CITY OF ALBUQUERQUE

**Planning Department
Transportation Development Services Section**

Re: **Certification for Permanent Building Certificate of Occupancy (C.O.)**
Lowes Parcels (Los Angeles Center, Tract A-1B-1-B & A-1-B-1-C), [D-18/D014D]
6230 Paseo del Norte
Architect's Stamp Dated 01/10/13

RE: Los Angeles Center (Lowes' out-parcels), Tracts A-1-B-1-B & A-1-B-1-C
Grading and Drainage Plan for Grading, Paving and Building Permit
SW Corner of Paseo del Norte & San Pedro PE Stamp: 7/11/12 (D18-D014D)

ENGINEER'S SEAL	LOS ANGELES CENTER	DRAWN BY WCU
MASTER UTILITY PLAN	DATE 3-28-12	
PLAN	21204-LAYOUT-3-28-12	SHEET #
DAVID SOULE P.E. #14522	<i>Pio Grande Engineering</i> 1006 CENTRAL AVENUE SUITE 201 ALBUQUERQUE, NM 87106 (505) 872-0999	JOB # 21204

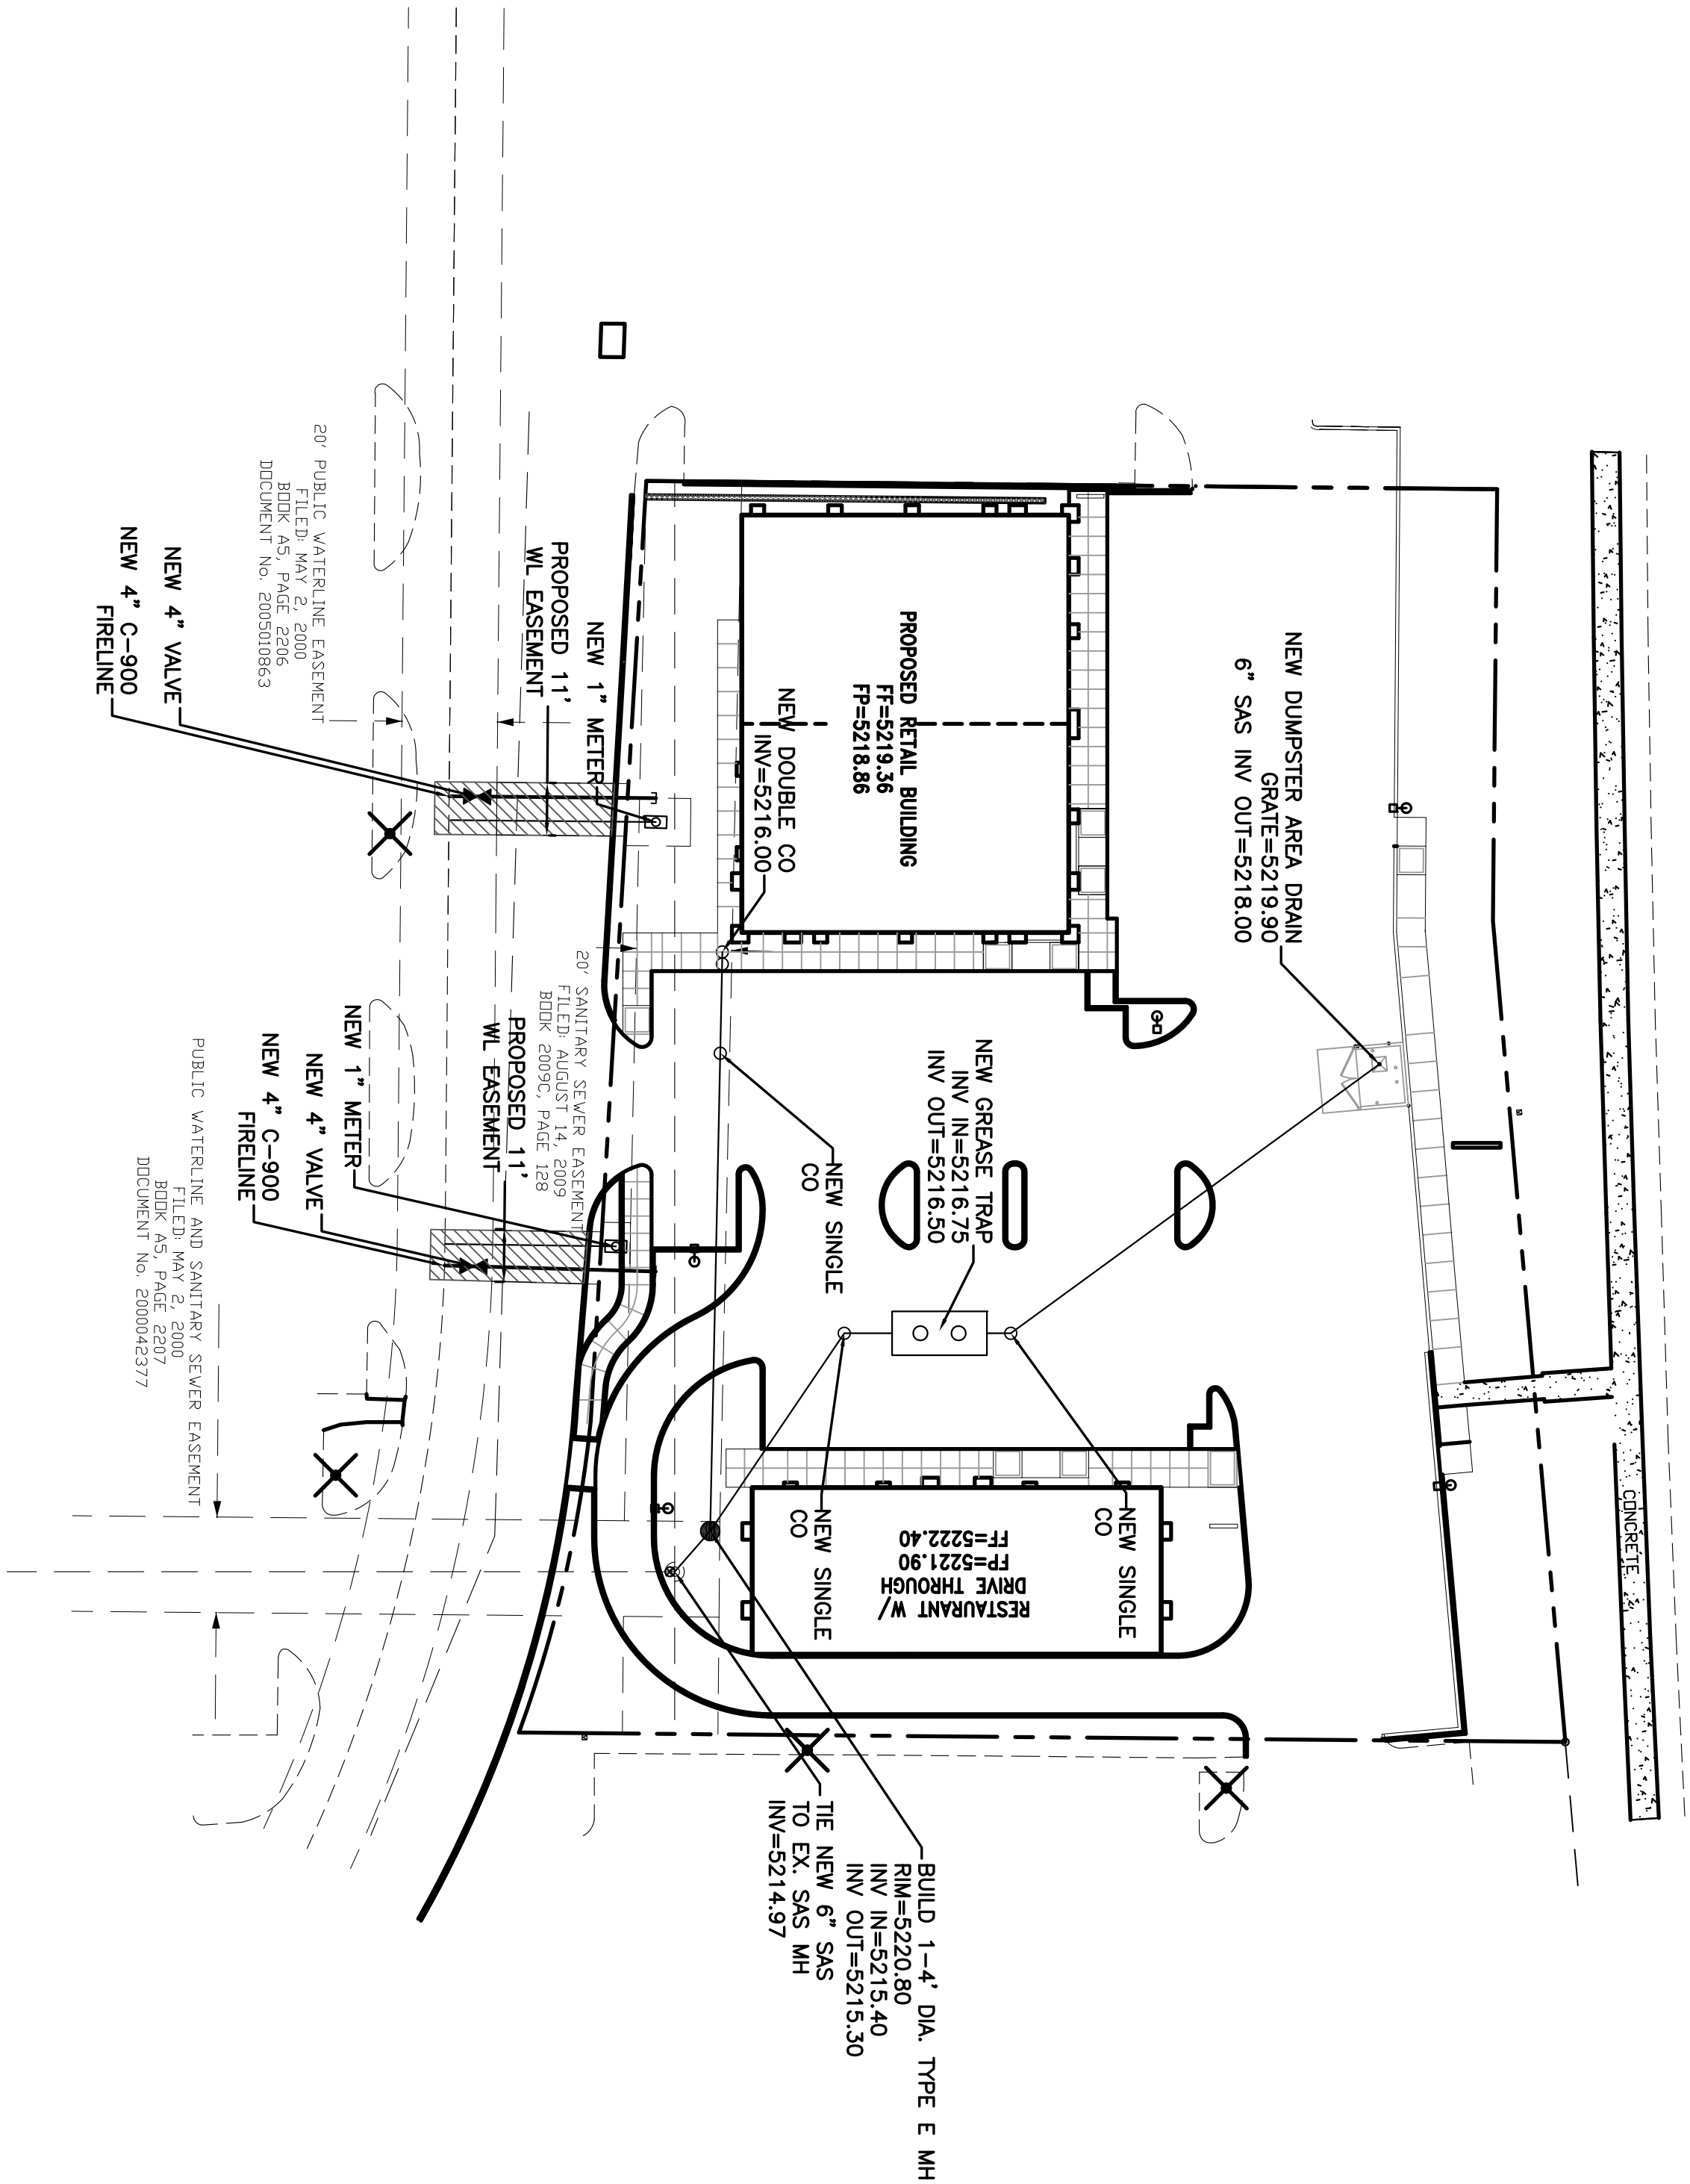
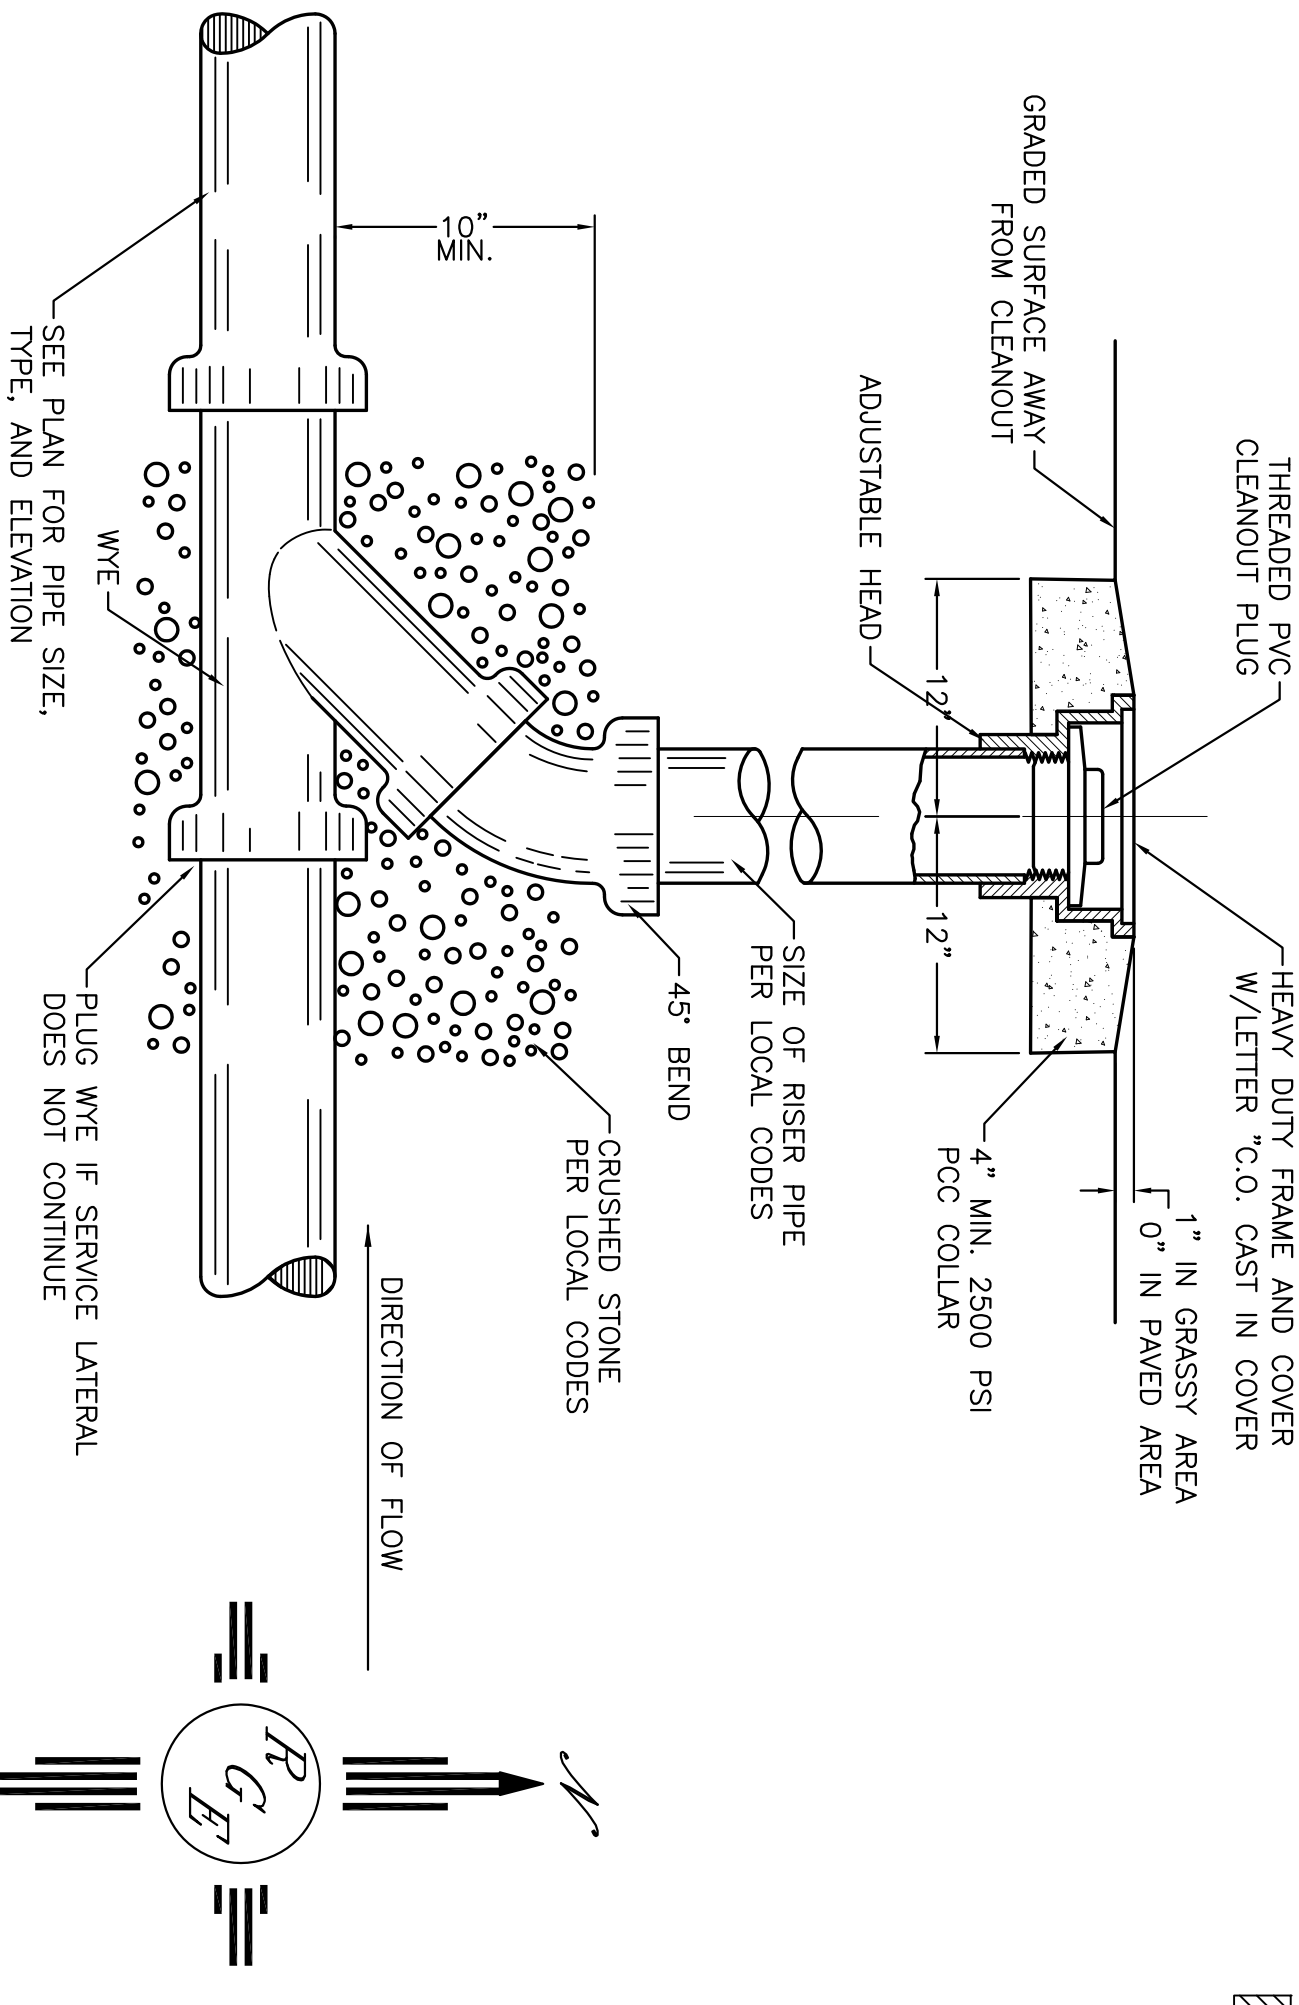
1. Per the DPM Chapter 22 Section 9, runoff from the trash enclosure pad is required to drain to the sanitary sewer.
2. The Building Permit set must include the revised Master Utility Layout, which shows the Dumpster Drain routed through a grease trap, with and approved discharge to the Sanitary Sewer system.
3. Albuquerque's MS4 Permit became effective March 1st, 2012. Grading and Drainage Plans and Drainage Reports must comply with the requirements of the new permit (<http://www.cabq.gov/planning/landcoord/Hydrology.html>).

2. Per DPM, the Dumpster pad for the restaurant must drain to the Sanitary Sewer.
Show this on the plan. -please add to both utility and grading

Revised SAS Plan
to Route Dumpster Drain
through Grease Trap
Rec'd 7/25/12
Meg Oller
